RE: Laukala Conditional Use Permit, (CU-08-07)

Thank you for the opportunity to comment on the above referenced project. Below are the comments for each division of Environmental Health that applies to Laukala Guest Ranch. These requirements are based on the information provided by Dennis Laukala on 3/31/08.

Holly Myers  
Environmental Health Director  
Kittitas County Public Health

Recreation building will have
restroom and shower facilities,
dining area and kitchen

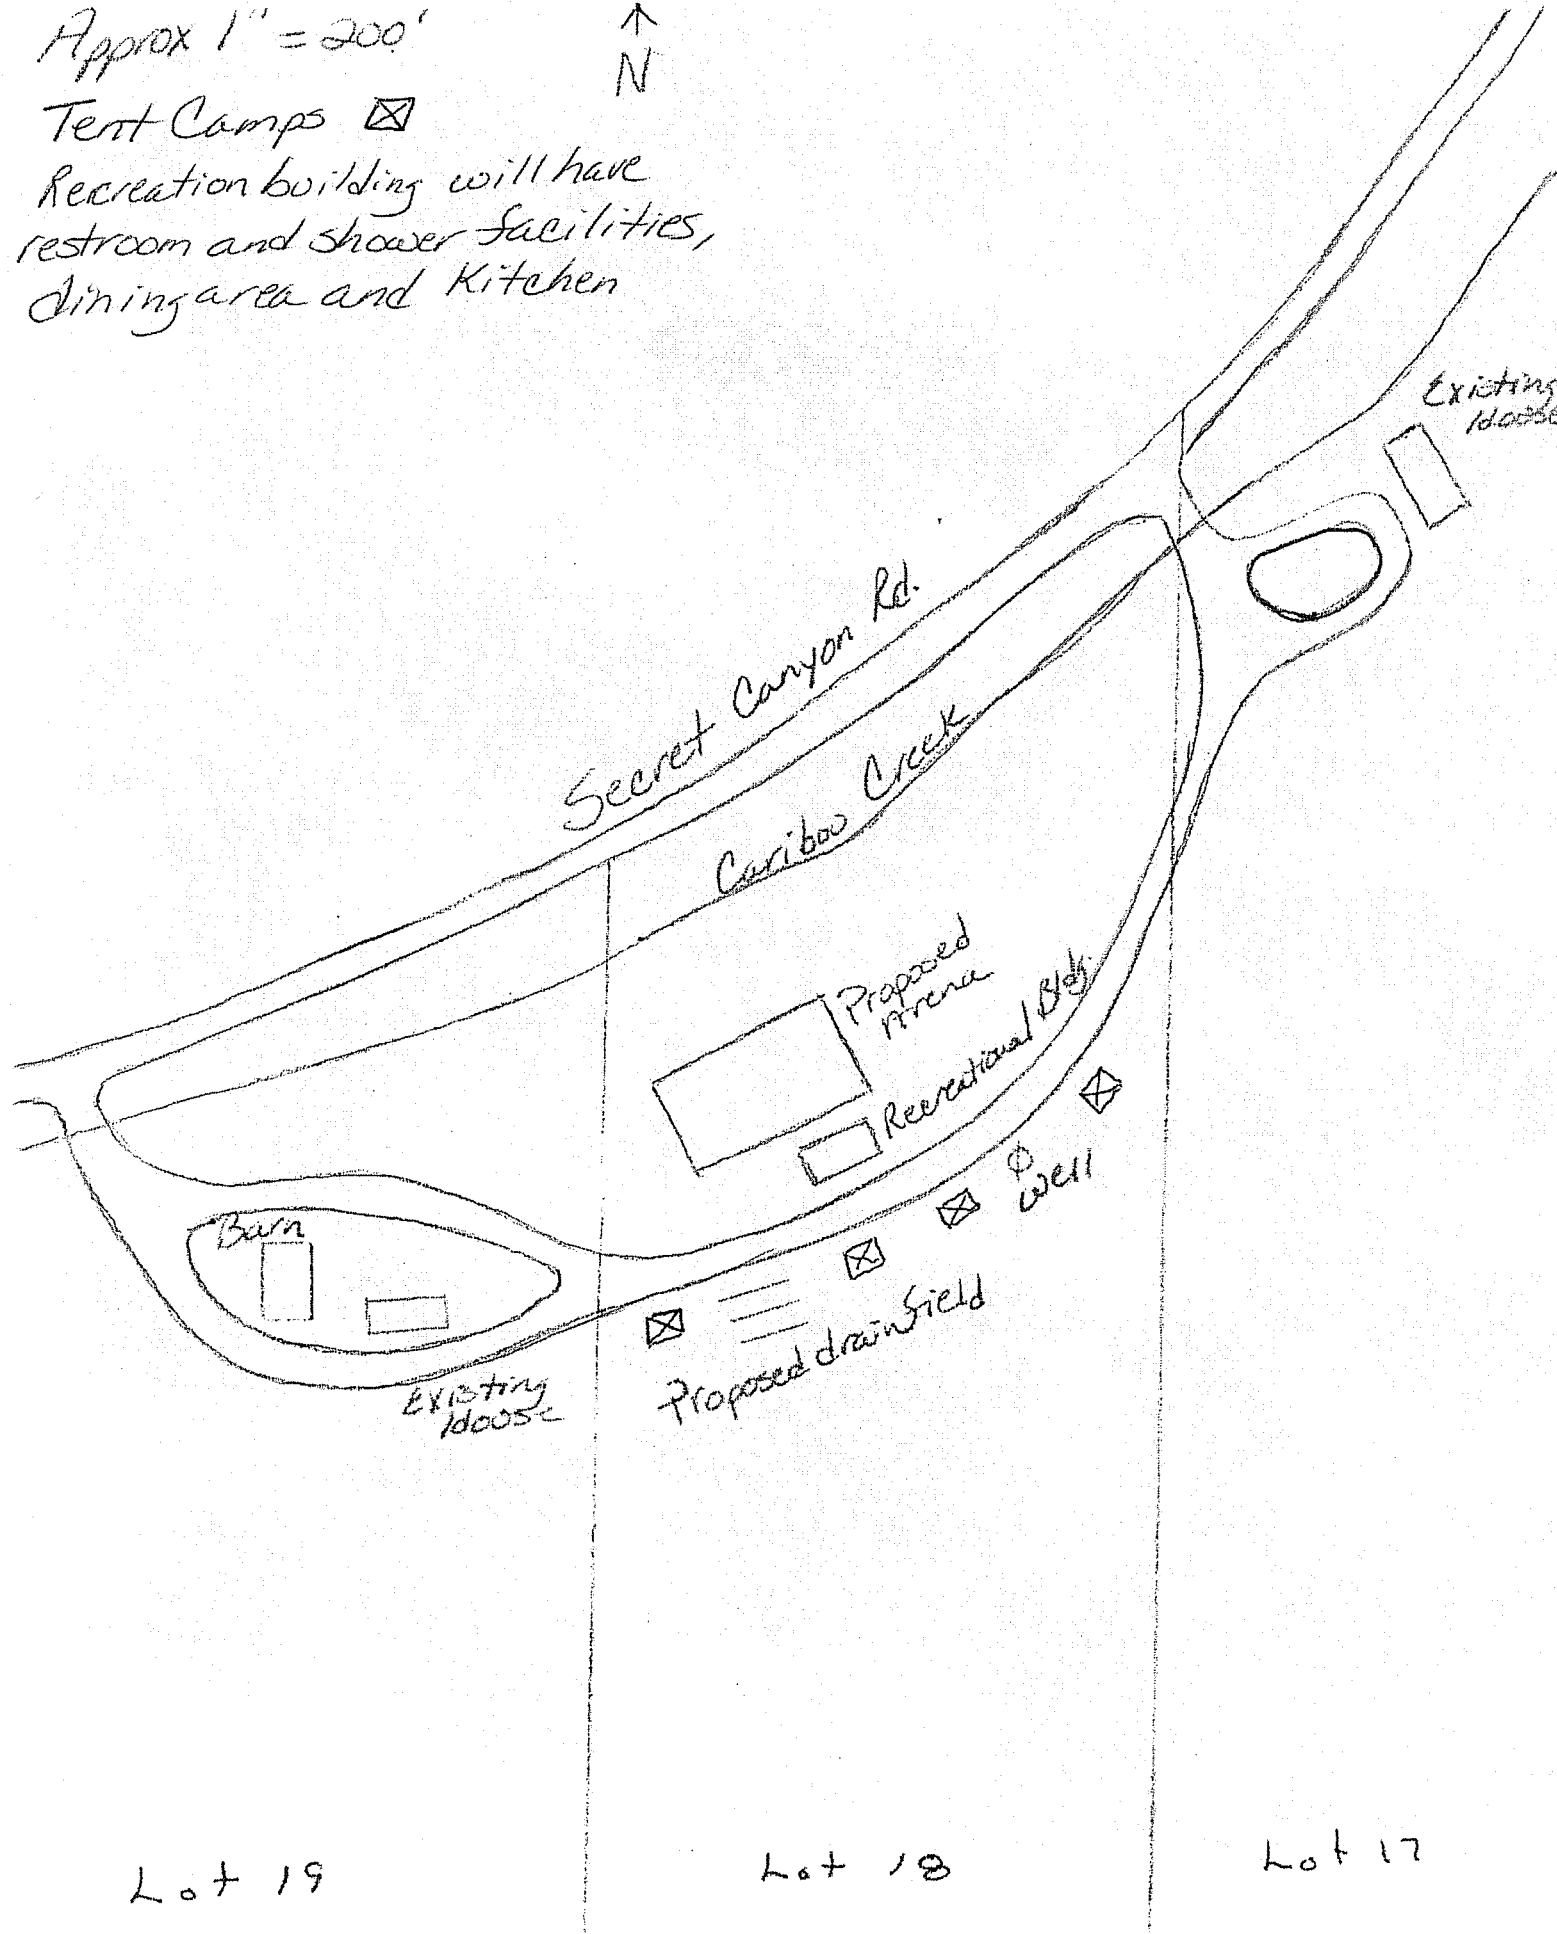
The applicant proposes a recreational building with restroom and shower facilities, a dining area and a kitchen. Any water provided to the public for consumption must originate from a drinking water source that is approved. If the applicant wishes to serve greater than 25 people for more than 60 days per year the water system would need to be approved as a Group A – Transient Non-Community system and must be licensed and approved by the Washington State Department of Health. The individual to contact is Tom Justus at (509) 456-2453.

If applicant is preparing food or offering concessions on site they must apply and receive a food service permit which includes an inspectors review and pre-opening inspection.

During the pre-application meeting regarding the Laukala CUP, Mr. Laukala proposed a bunkhouse and a separate bathhouse for the campers. In order for a bathhouse to be permitted and constructed a site evaluation must be done to determine septic availability. An average daily flow must be determined (based on EPA Manual Flows) by a licensed septic designer and EH staff. A septic design must be submitted by a licensed designer then reviewed and approved by EH staff. Once these steps are complete a building permit can be released and septic construction can begin.
